**85 HARRINGTON STREET
THE ROCKS**

ACCESS REVIEW

Morris Goding Accessibility Consulting

25th January 2016

1 PLAN 1 BED - Pre-Adapted Layout
1:50

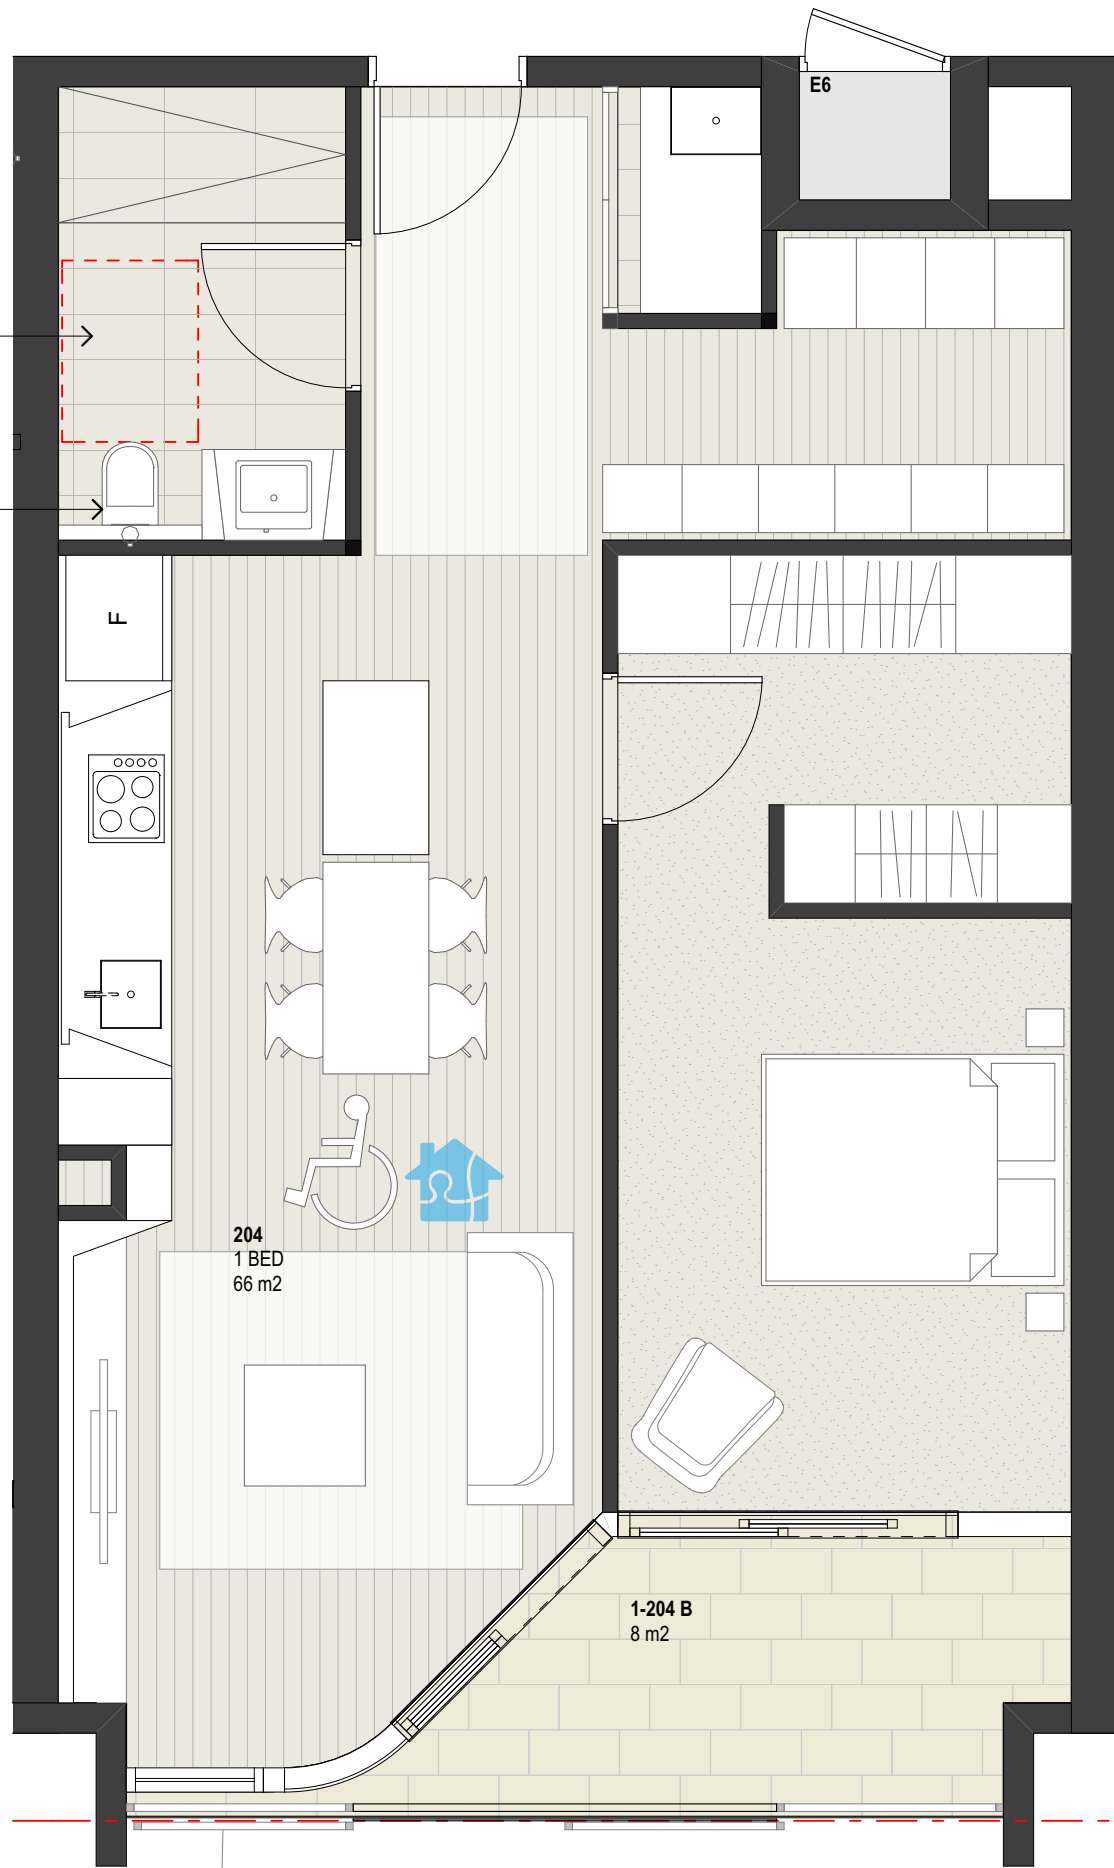
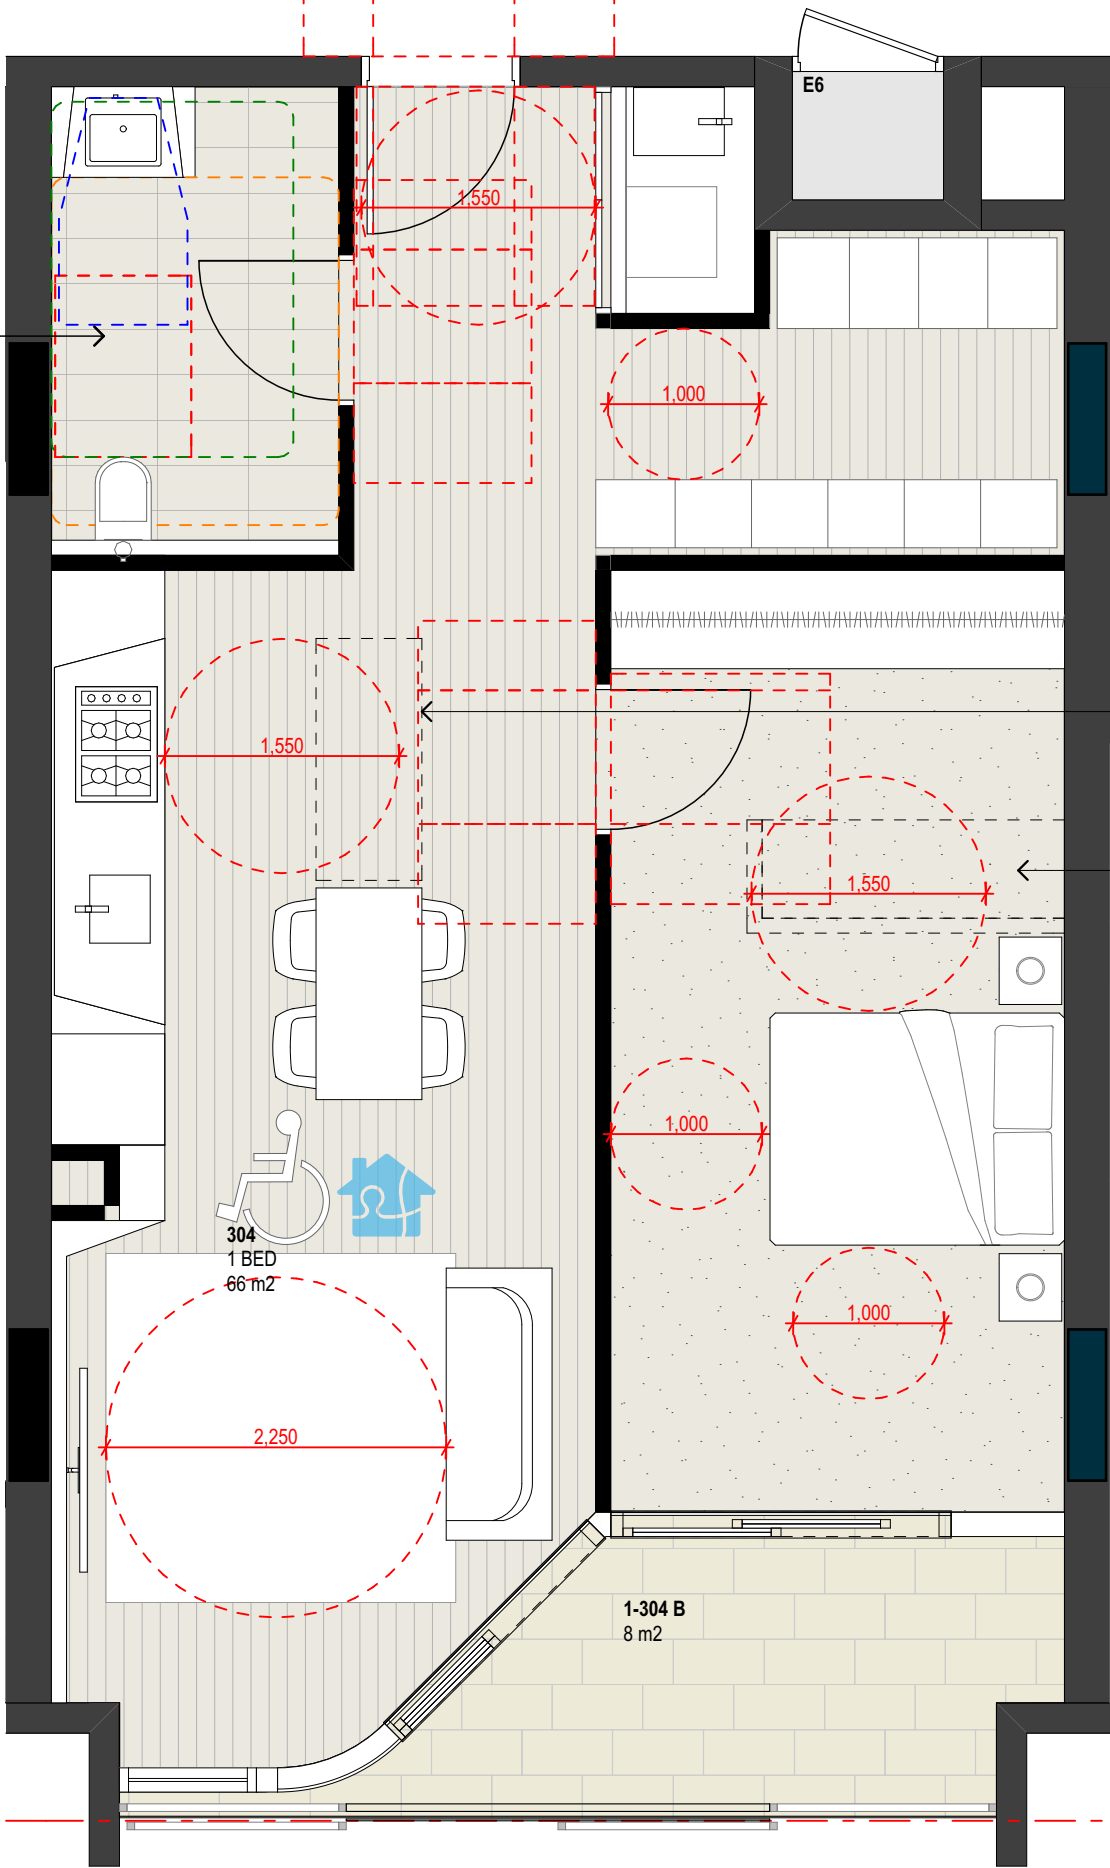
The entry door of the apartment achieves 850mm clear width opening (920 door leaf) at pre and post adaptation. Latch side clearance is achieved at pre adaptation, externally of the door, and can be achieved internally by the removal of the laundry wall at post adaptation. Review is required of the laundry wall to be removed. The removal of this wall at post adaptation will achieve 1550 outside of the laundry appliances.

The kitchen can achieve 1550mm circulation space outside of the kitchen work spaces at post adaptation by the relocation of kitchen benches.

The bathroom is of an adequate size to achieve an AS1428.1 compliant bathroom of shower, WC and basin with required circulation spaces. The bath is freestanding and will be removed at post adaptation. Capped off services are provided for the relocation of WC and basin at post adaptation. The shower is to use bath waste at post adaptation. Review is required to provide shower tap ware in post adaptation location from the outset, compliant with AS4299.

Review is required of all doors within the apartment to achieve 850mm clear opening width from the outset; this includes access to the balcony.

- (i) Ensure any wall that is removable at post adaptation is free of services, compliant with AS4299.
- (ii) Ensure shower tap ware is located in post adaptation location from the outset to reduce the cost of adaptation, compliant with AS4299.
- (iii) All doors to achieve 850mm clear opening width from the outset and easily achievable latch side clearances at post adaptation, compliant with AS1428.1:2009.
- (iv) Provide continuous tiling under benches to be relocated and capped off services in the kitchen to achieve low level modification of the kitchen, compliant with AS4299.
